From: [REDACTED]
To: [Shaun Williams](#)
Subject: HPE CM: RE: HPE CM: RE: HPE CM: FW: Smeaton Grange - Follow up from call with Council
Date: Monday, 13 August 2018 3:05:57 PM
Attachments: [image014.png](#)

As previously mentioned, EMM consulting on behalf of Roussakis Holdings Pty Ltd is additionally seeking the modification of Condition B61 (attached) as part of the modification application to the Smeaton Grange Resource Recovery Facility (SSD 7424 MOD 1) pursuant to section 4.55(1a) of the *Environmental Planning and Assessment Act 1979*.

FRONT FENCE DETAIL PLAN  
SCALE 1:200

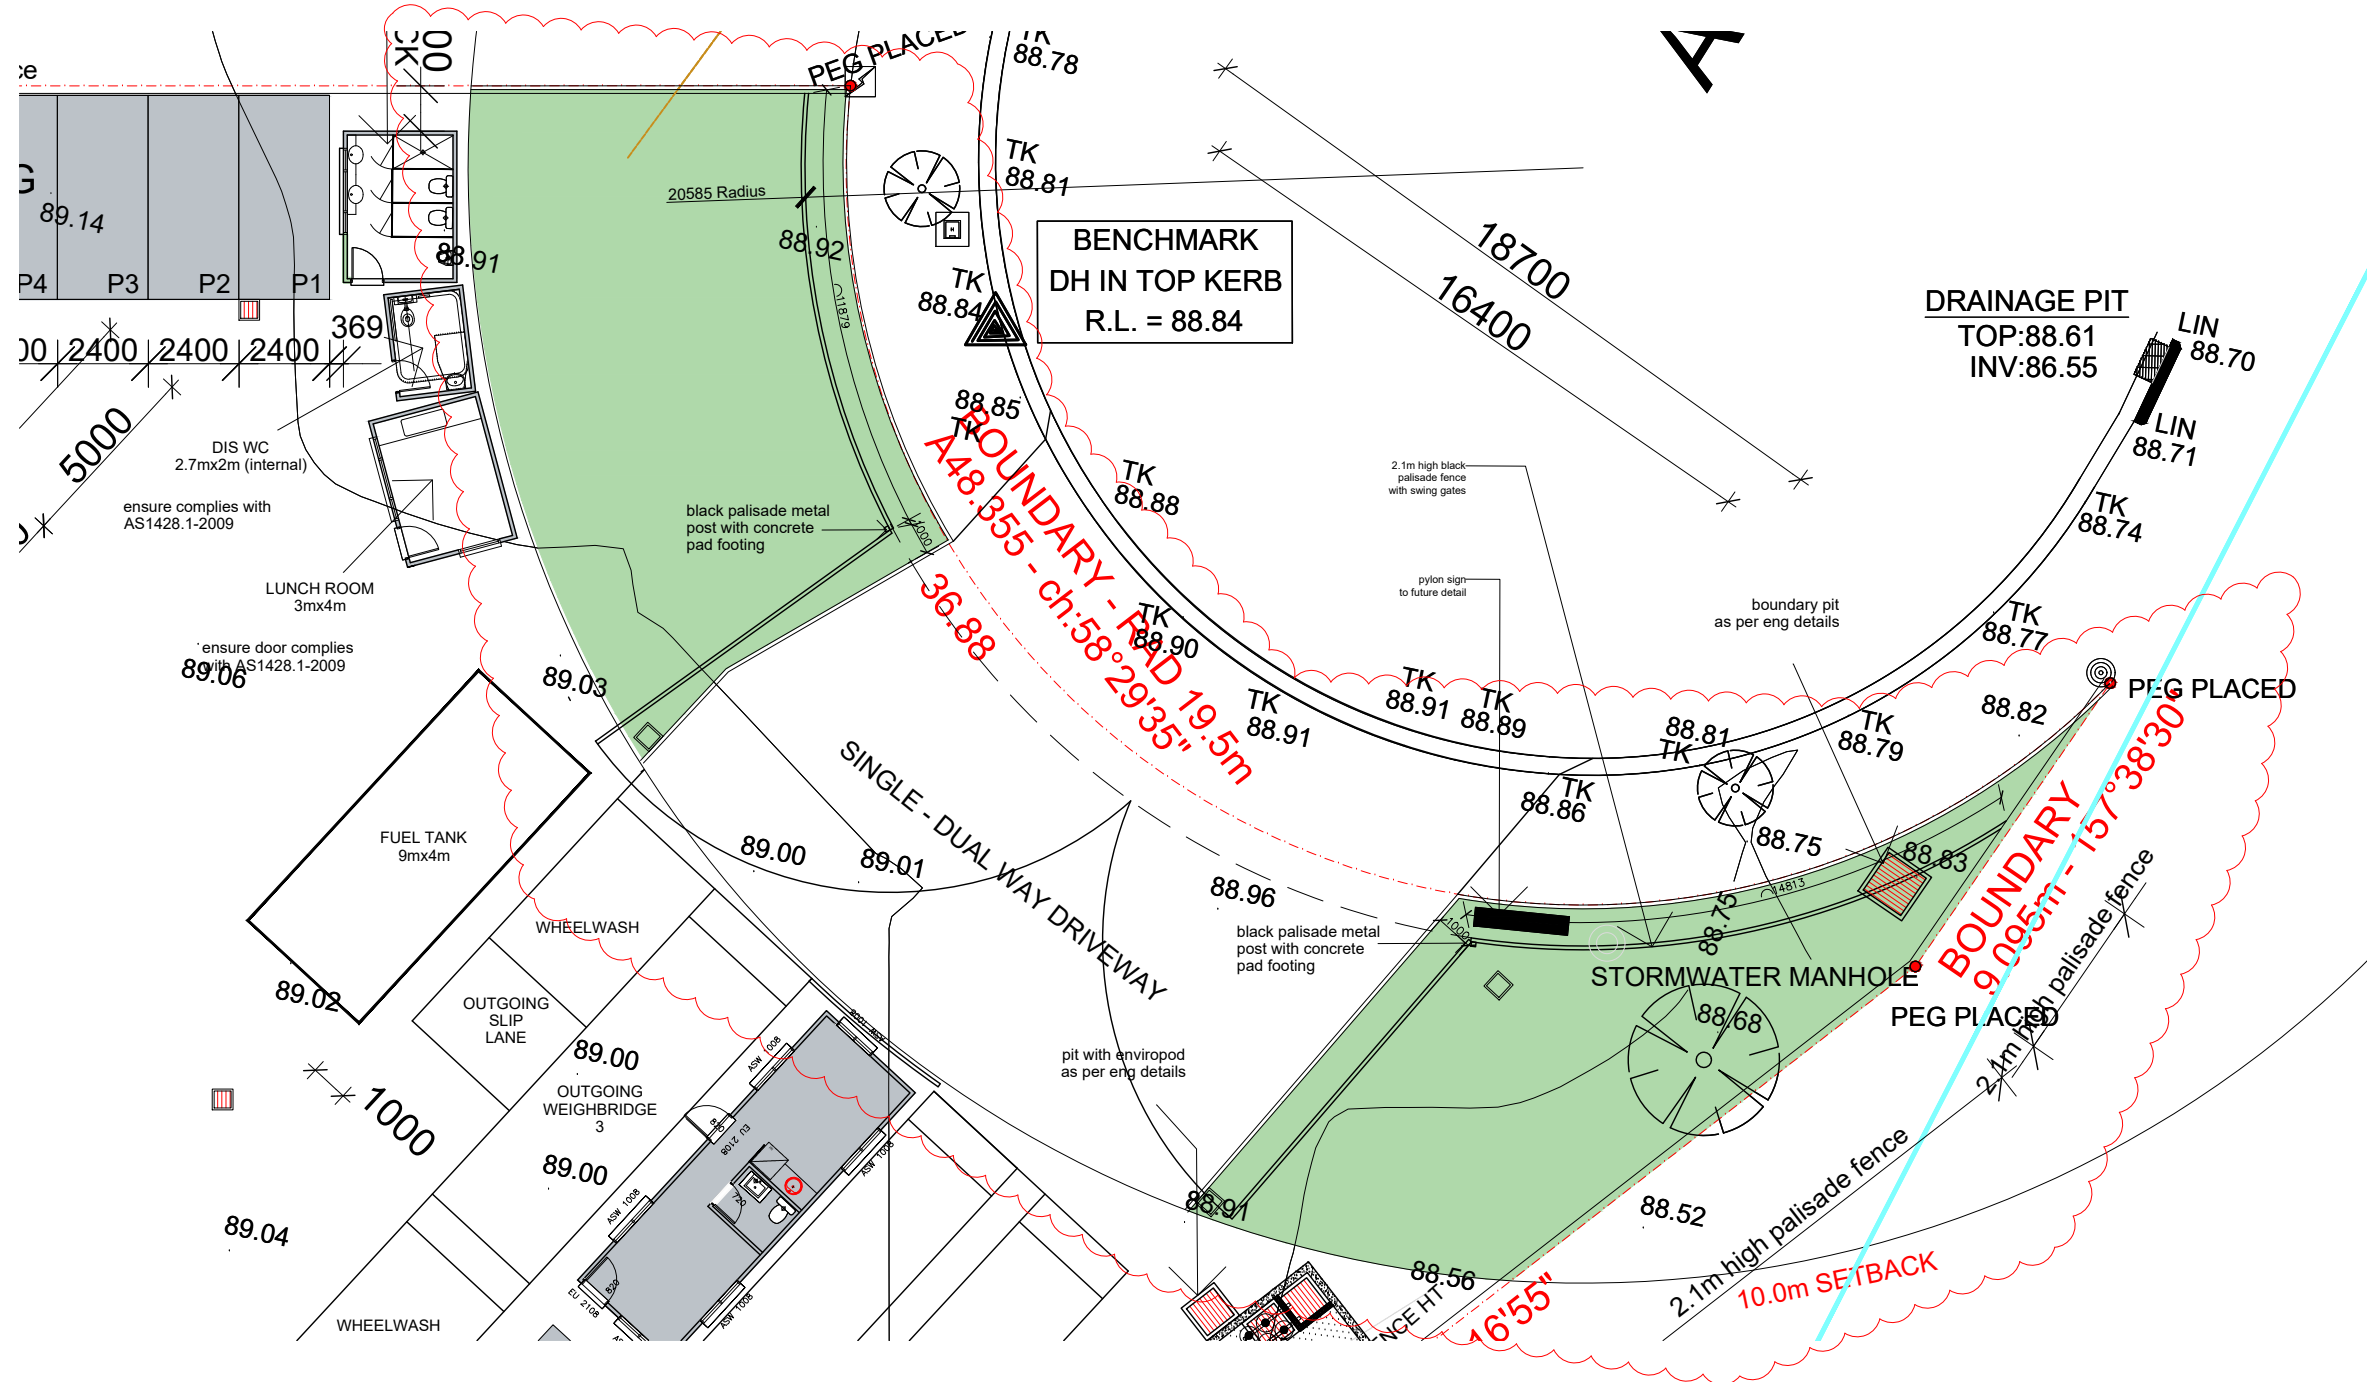
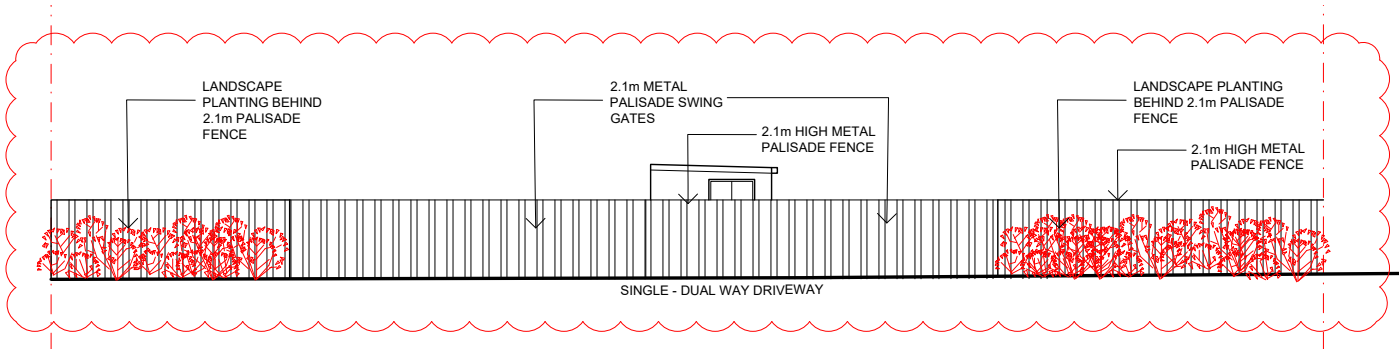
Council has previously expressed its position in relation to the front fencing treatment for the proposed development. As noted in my previous email of 30 July 2018 to the proponents environmental consultant (and cc'd to your email address), Council's preference is for a decorative masonry fence to the front of the property to effectively screen the proposed use from the street in conjunction with suitable landscaping treatment located in front of this fencing. Council maintains this position.

Recent documentation forwarded by the applicant increased the landscaping planting densities within the front setback area as requested by Council, and this landscape treatment is now acceptable. However, Council maintains that this modified landscape planting arrangement within the front setback area be situated in front of a decorative masonry wall rather than in front of a 2.1 metre high metal palisade fence setback 1.0 metre from the front property boundary.

While it is accepted that the applicant's proposed fencing treatment may generally comply with Council's DCP controls, given the nature of the proposed development, which involves external activities exposed to view (rather than being contained within a building) a more substantial screening treatment should be adopted to reduce potential visual impact of the proposed development. Council does not accept that landscape planting in conjunction with metal palisade fencing will provide sufficient visual screening, and certainly not until landscape planting has reached a mature height.
